# Conservation Area Advisory Committee

Meeting Date : 1 September 2014

| Ref                                                                                                                                                                                           | Description                                                                                                                                                                                                                                                                                                                                                          | Address                   | Design award |
|-----------------------------------------------------------------------------------------------------------------------------------------------------------------------------------------------|--------------------------------------------------------------------------------------------------------------------------------------------------------------------------------------------------------------------------------------------------------------------------------------------------------------------------------------------------

DRAWING TITLE
PROPOSED FLOOR PLANS, ROOF PLAN,
SECTION AND ELEVATIONS

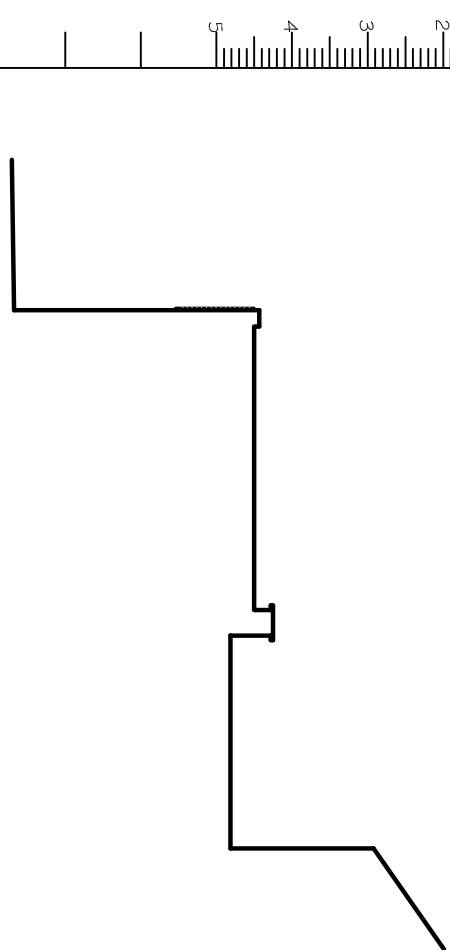
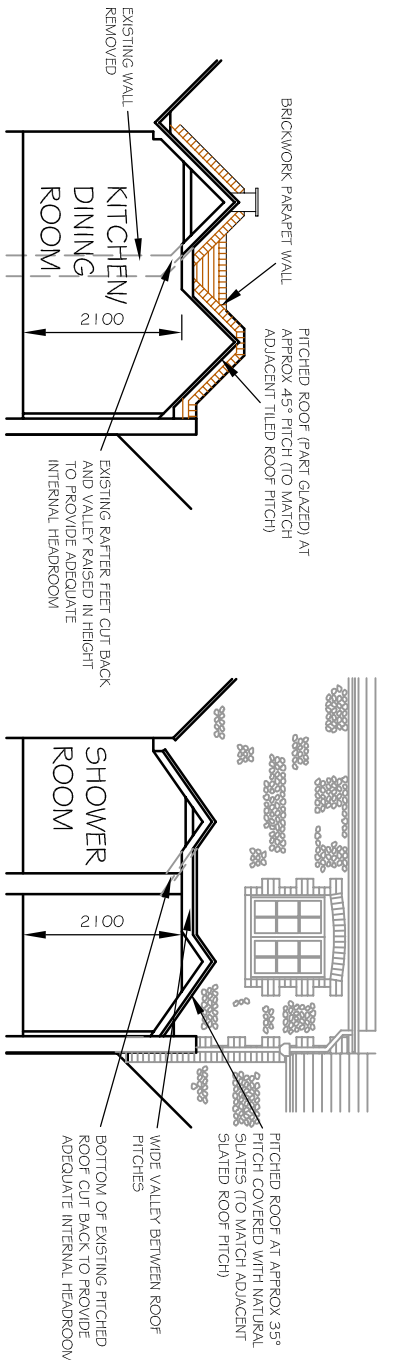
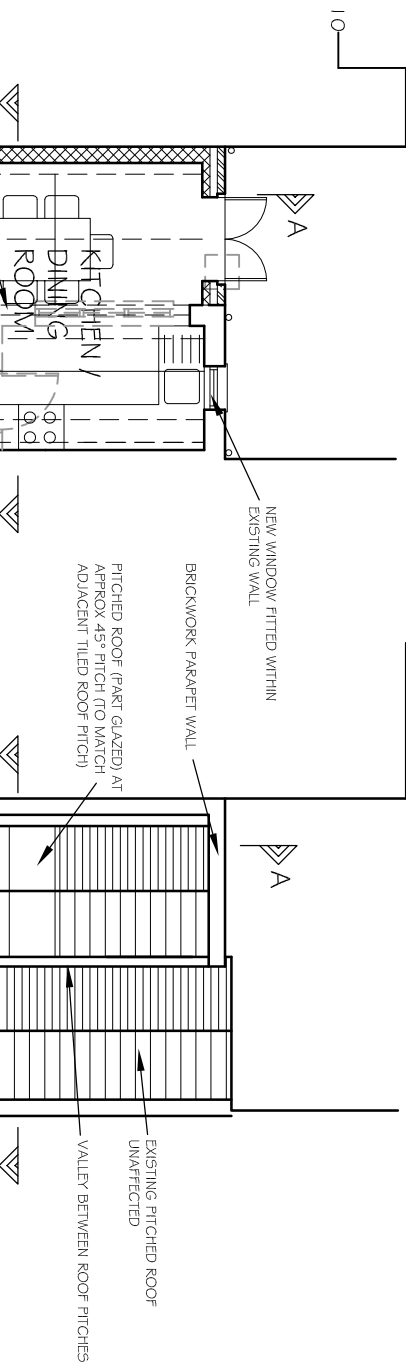
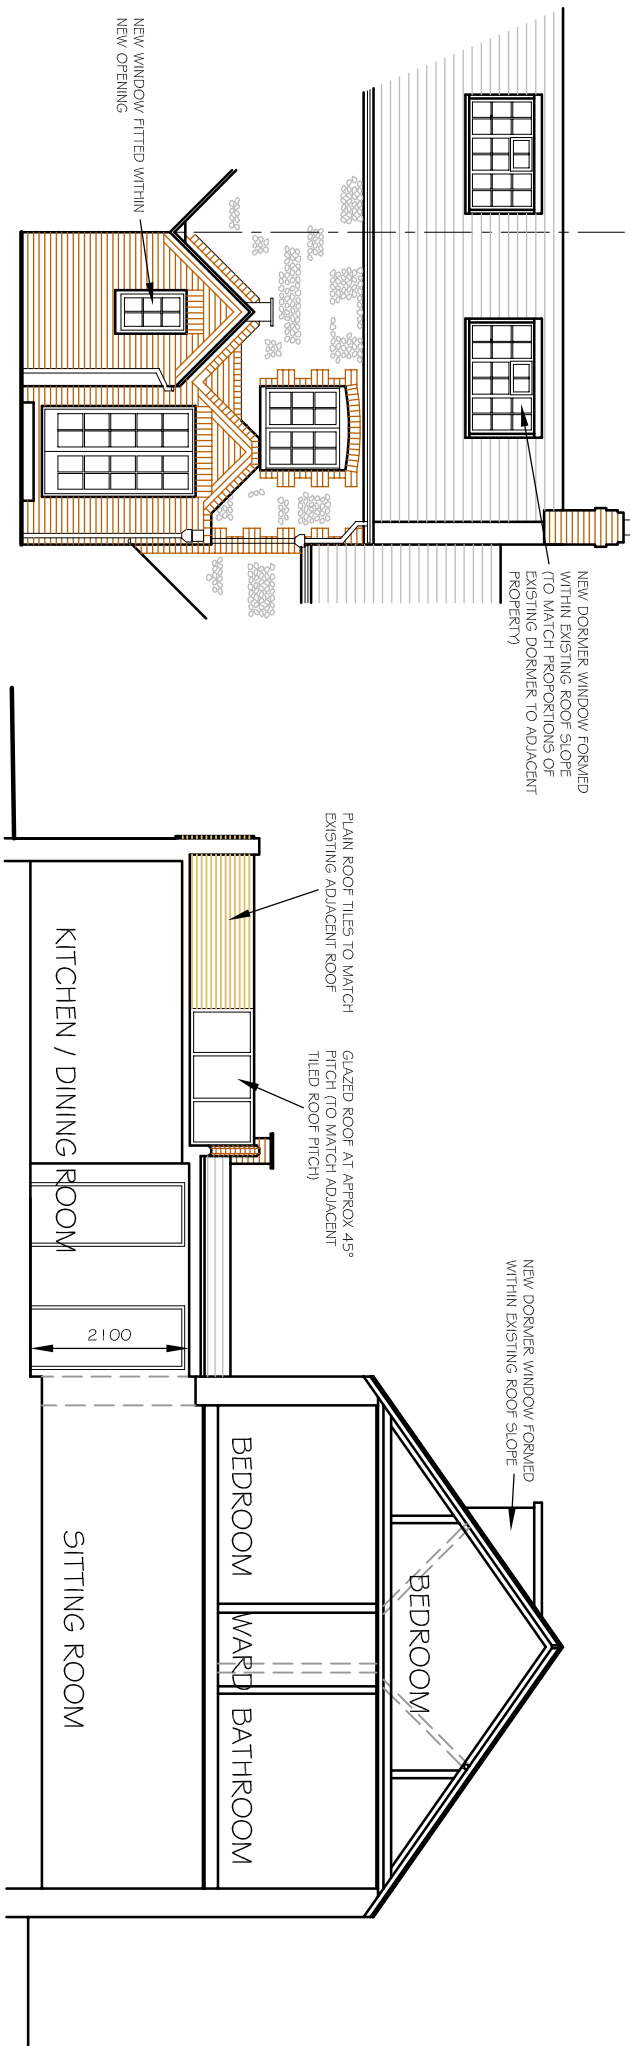
| Ref                                                                                                                                                                                           | Description                                                                                                                                                                                                                                                                                                                                                          | Address                   | Design award |
|-----------------------------------------------------------------------------------------------------------------------------------------------------------------------------------------------|----------------------------------------------------------------------------------------------------------------------------------------------------------------------------------------------------------------------------------------------------------------------------------------------------------------------------------------------------------------------|---------------------------|--------------|
| <p>Comments: <i>No objection</i></p> <p>Suggested Conditions:<br/> <i>Planes to see that infed domes would have been Ford Roundabout - would prefer domes would not be one over porch</i></p> |                                                                                                                                                                                                                                                                                                                                                                      |                           |              |
